COUNCIL SUBMISSION – Sydney Metro West - Parramatta Metro Station - Over and Adjacent Station Development EIS (SSD- 35538829) - public consultation

EXECUTIVE SUMMARY

1.1 Massing Envelope

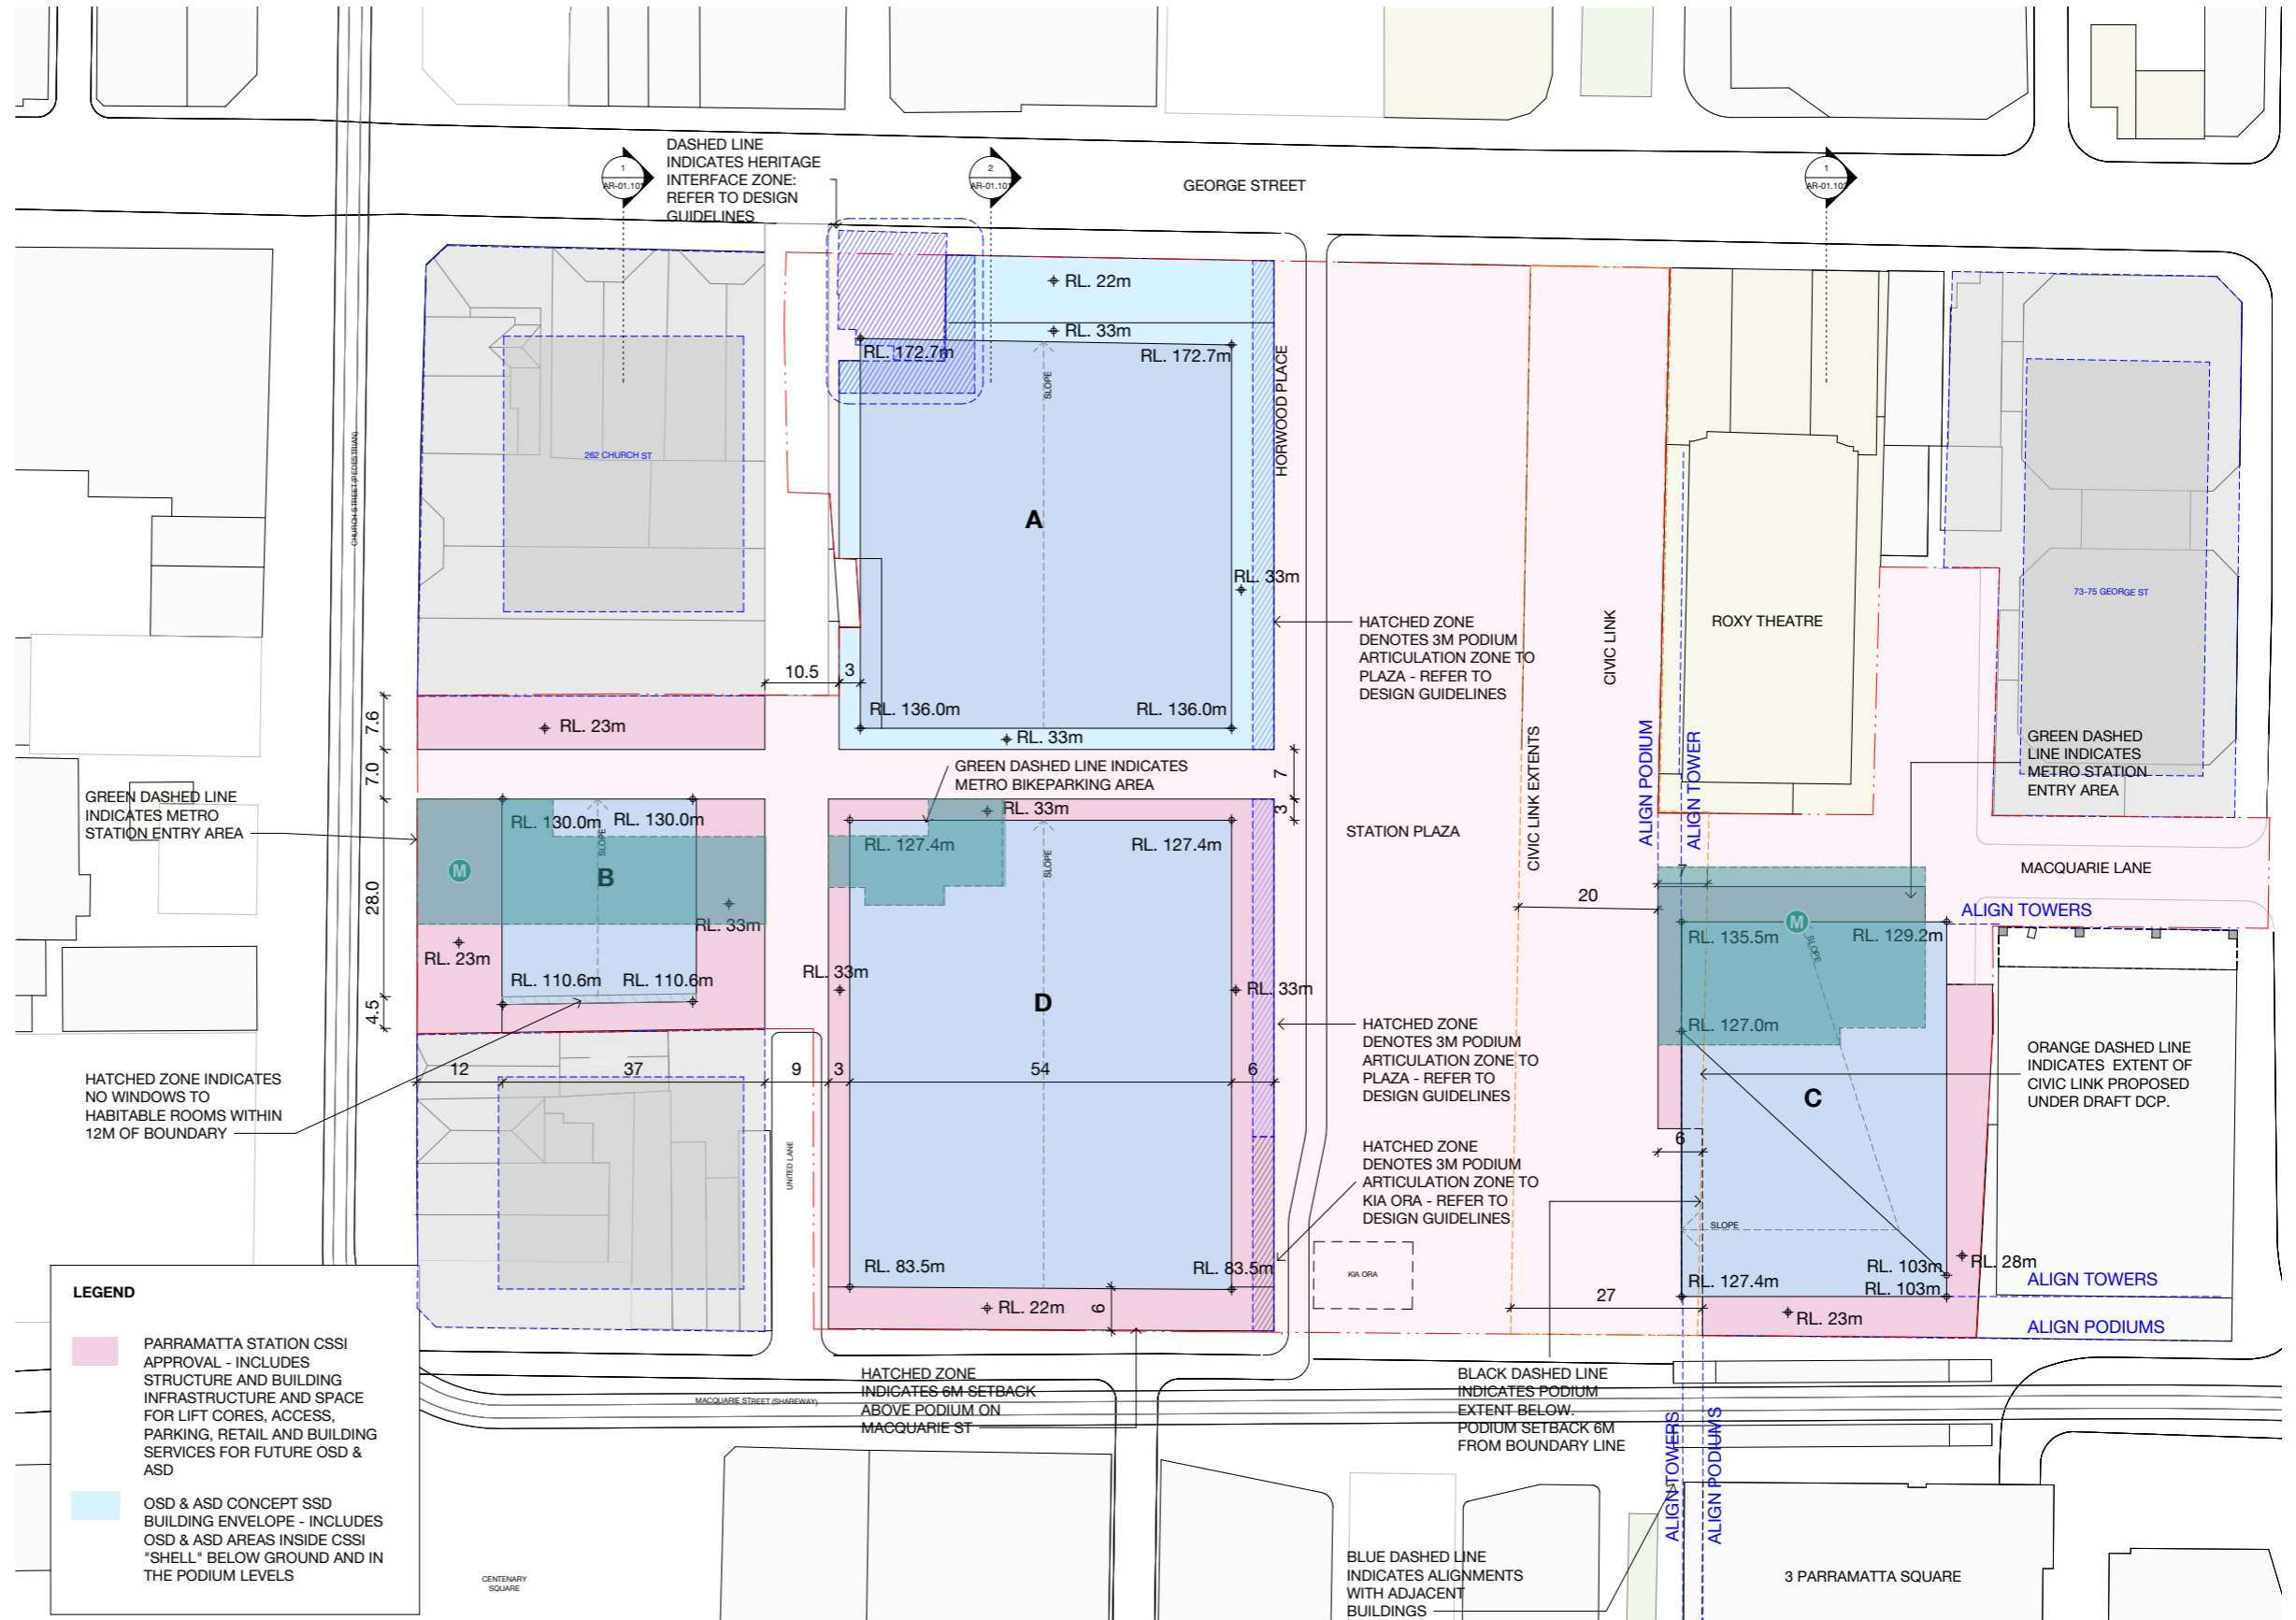
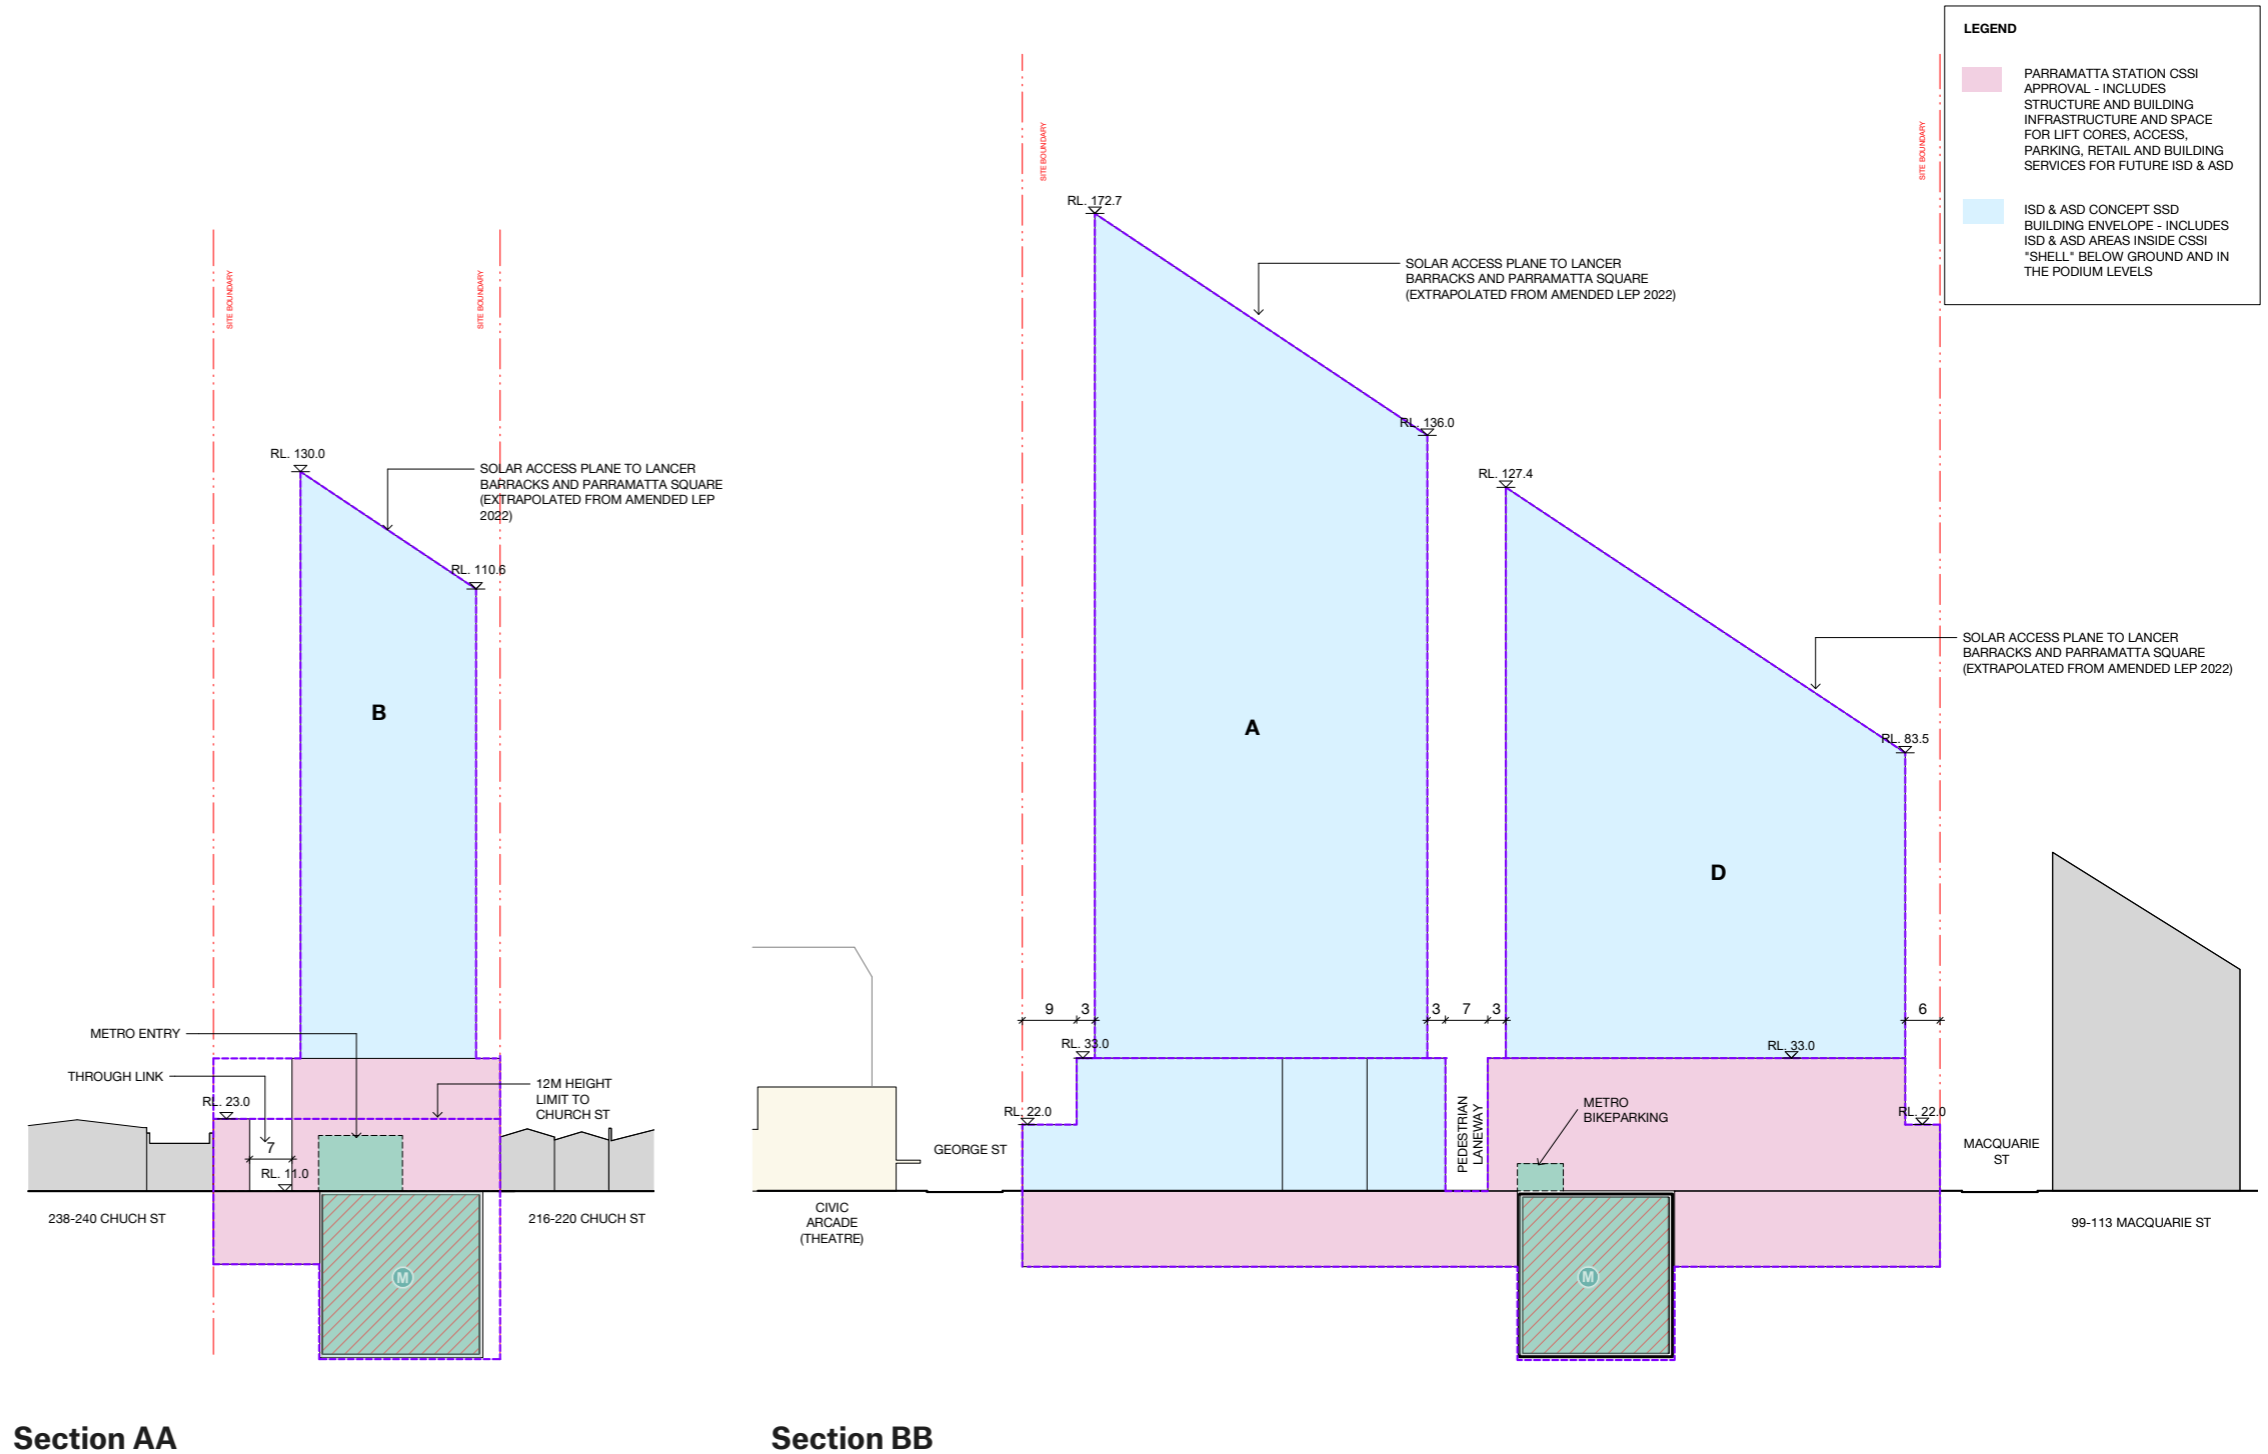
- Building C and the eastern metro entrance location, which appears to be sited within the extension of Macquarie Lane, are not sufficiently described with contradictory outcomes shown in different parts of the documentation. The encroachment of the Metro station into the public domain of Macquarie Lane is not accurately assessed for pedestrian circulation and the relationship to the Roxy. The street wall height of Building C at Macquarie Lane and Civic Link does not align with Council DCP and an alternative approach is not justified.

The building envelope drawings and Design Guidelines are amended to include all proposed buildings, their interface with the public domain and heritage buildings.

PARRAMATTA METRO OSD				
PARRAMATTA STATION ARCHITECTURE				
GROUND LEVEL				
FILE No:			SHEET: OF	©
STATUS: POC			EDMS No:	
DRG No:SMWSTEDS-SMD-PTA-DRG-AR-02.001			REV 6	VER

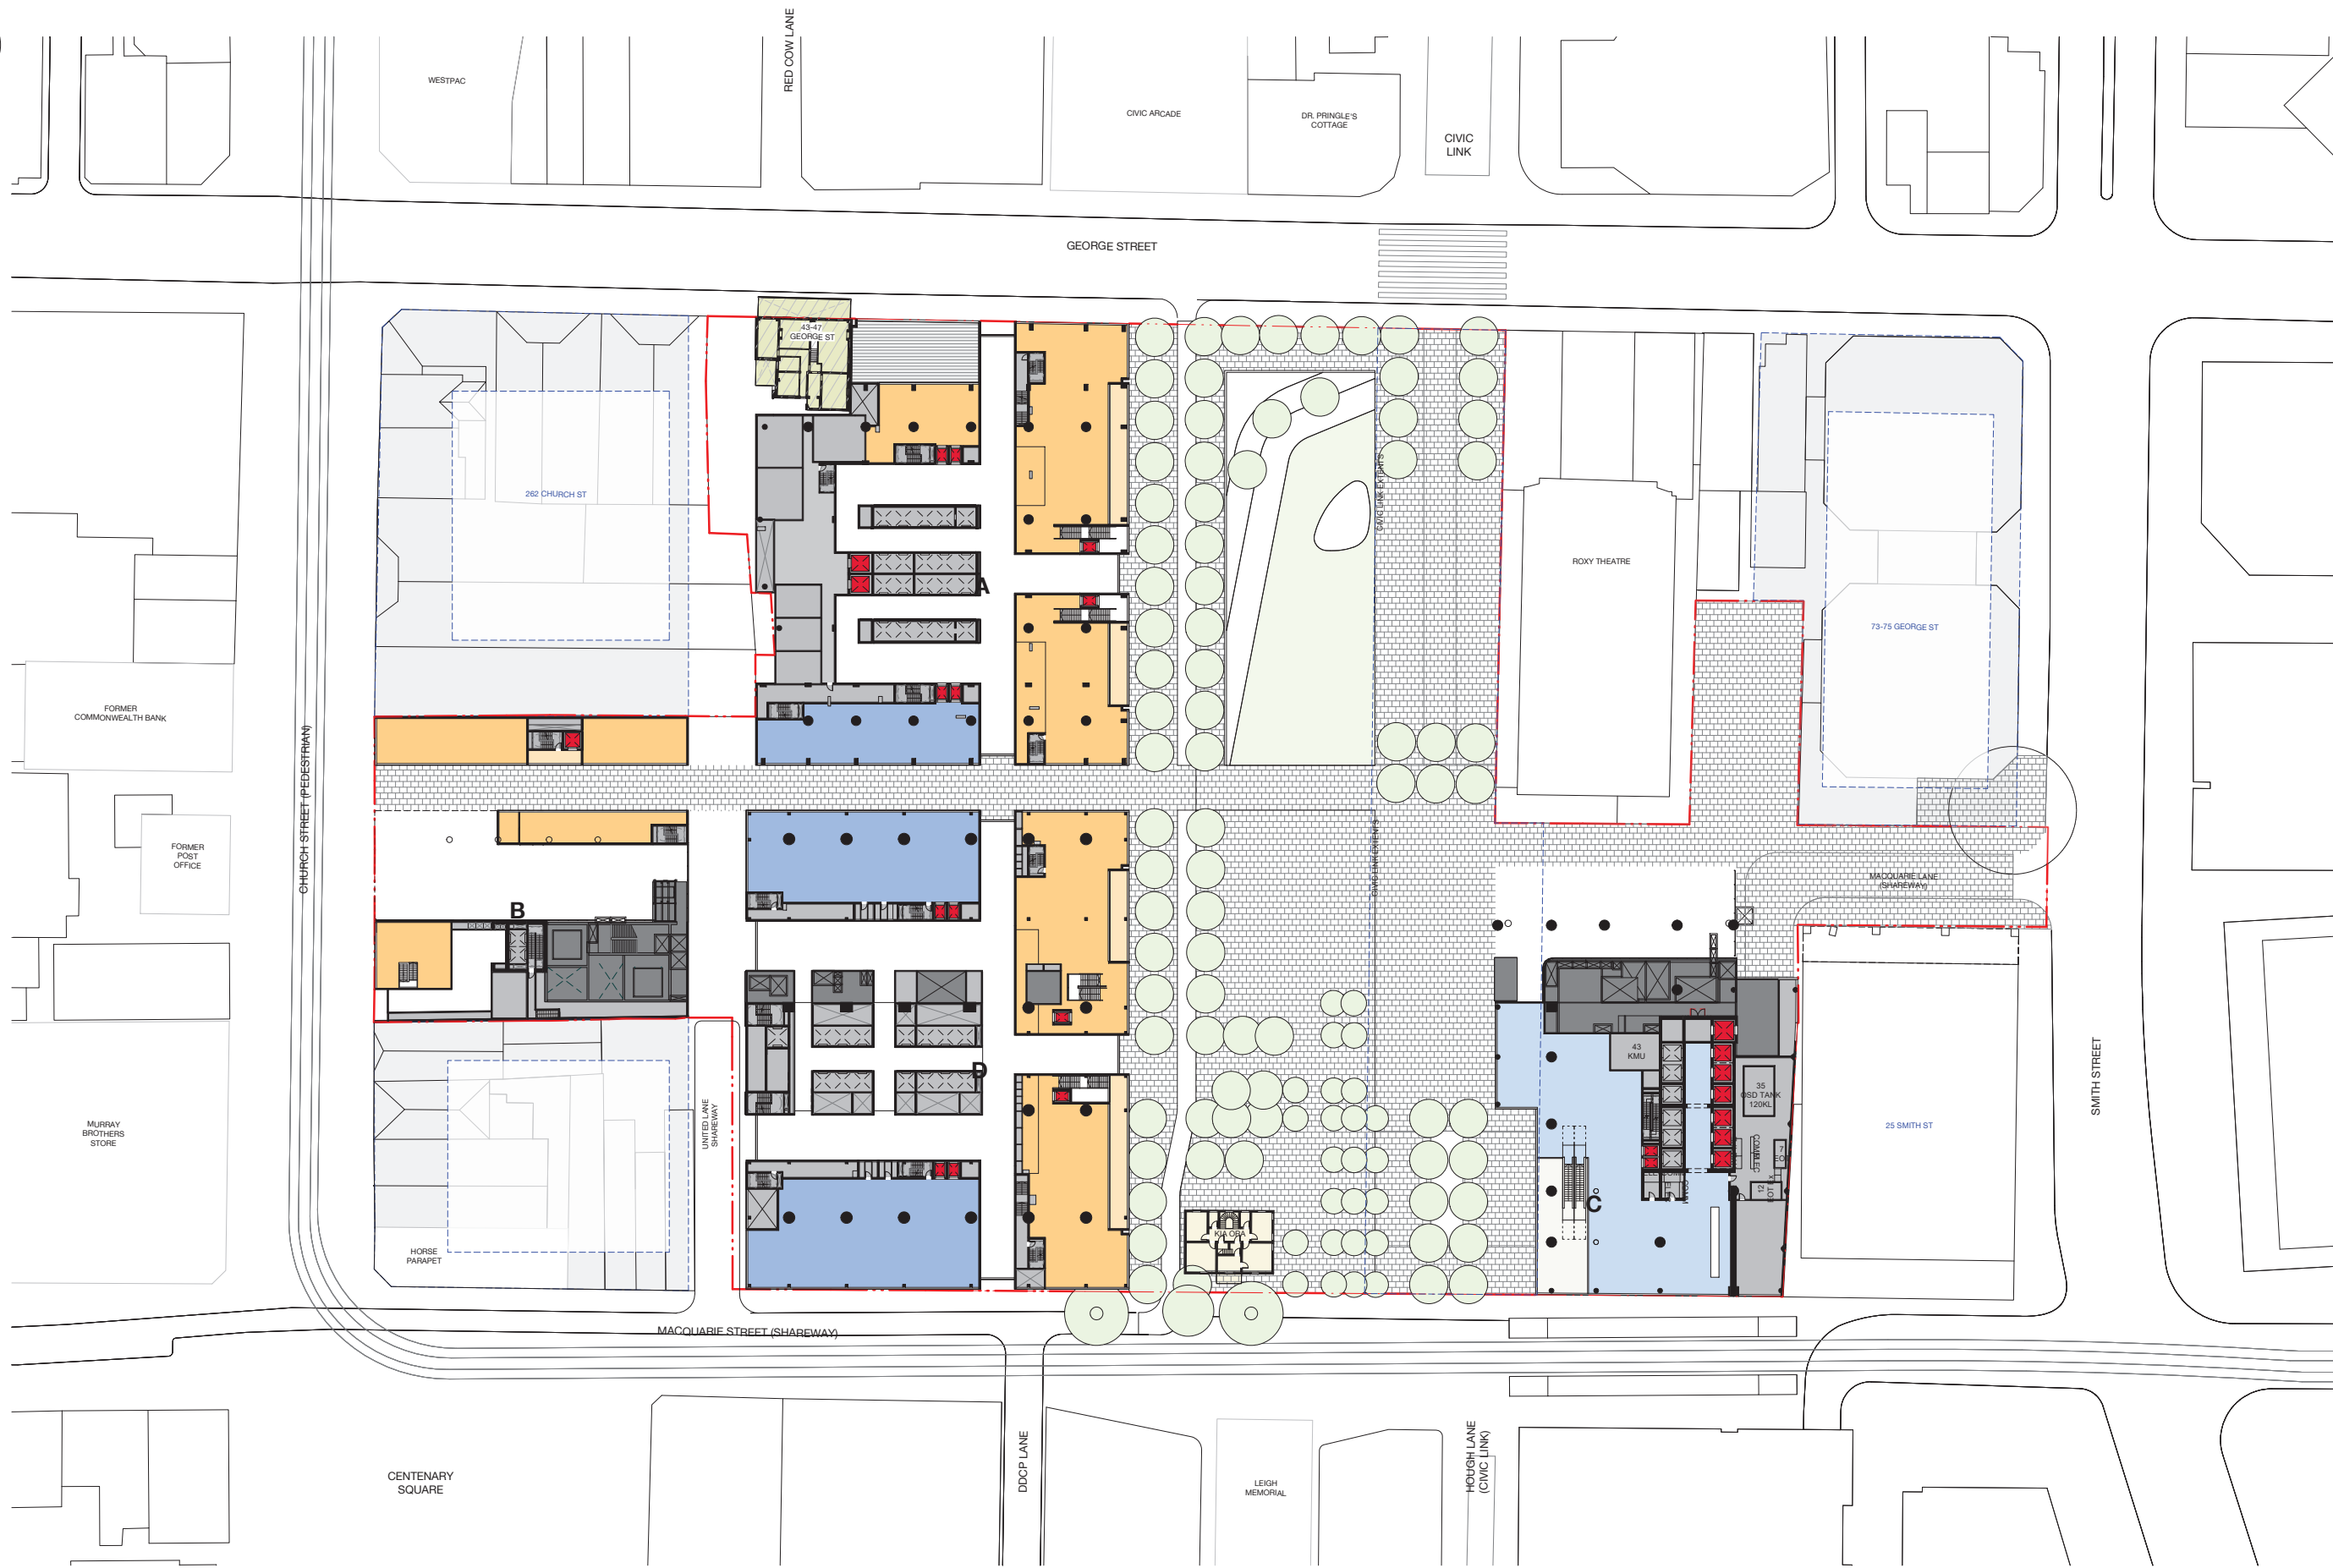
The eastern extent of the podium and tower of Building A and D disrupts the alignment of New Horwood Place and creates insufficient separation between the heritage listed Kia Ora and new development to the west.

- The alignment of New Horwood Place is kinked around Kia Ora cottage. A straight street alignment with a 14m street reserve is required (as per Council's DCP) to provide sufficient space for a footpath along the western side of Kia Ora cottage and tree planting for separation and a green backdrop to the cottage. The kinked street alignment does not acknowledge the heritage setting and visually terminates on the north-west corner of the rear façade of the cottage.

- The kinked street creates a poor street edge definition to Welcome Square and constrains the space to the north of the cottage which will limit options for future heritage sensitive additions to the rear of the cottage.

- The turning radius from Macquarie Street to New Horwood Place does not appear to be sufficient. Emergency and service vehicles should be accommodated.

- Horwood Place is shown as a single lane. More information is required to quantify the likely traffic volume from the south and south-west of the Metro site and to demonstrate the capacity of the single lane carriageway to accommodate the required traffic.

- Building A and Building D should be setback to accommodate a 14 m road reservation with a straight carriageway alignment. Alternatively, Kia Ora could be relocated to the east to centrally aligned with the Leigh Memorial Church to enable a 14m road reservation with a straight carriageway alignment.

The alignment of Horwood Place be straightened with a straight 14m street reservation width to accommodate parking, footpaths and tree planting along both sides of the street and to ensure Kia Ora has an appropriate curtilage and setting.
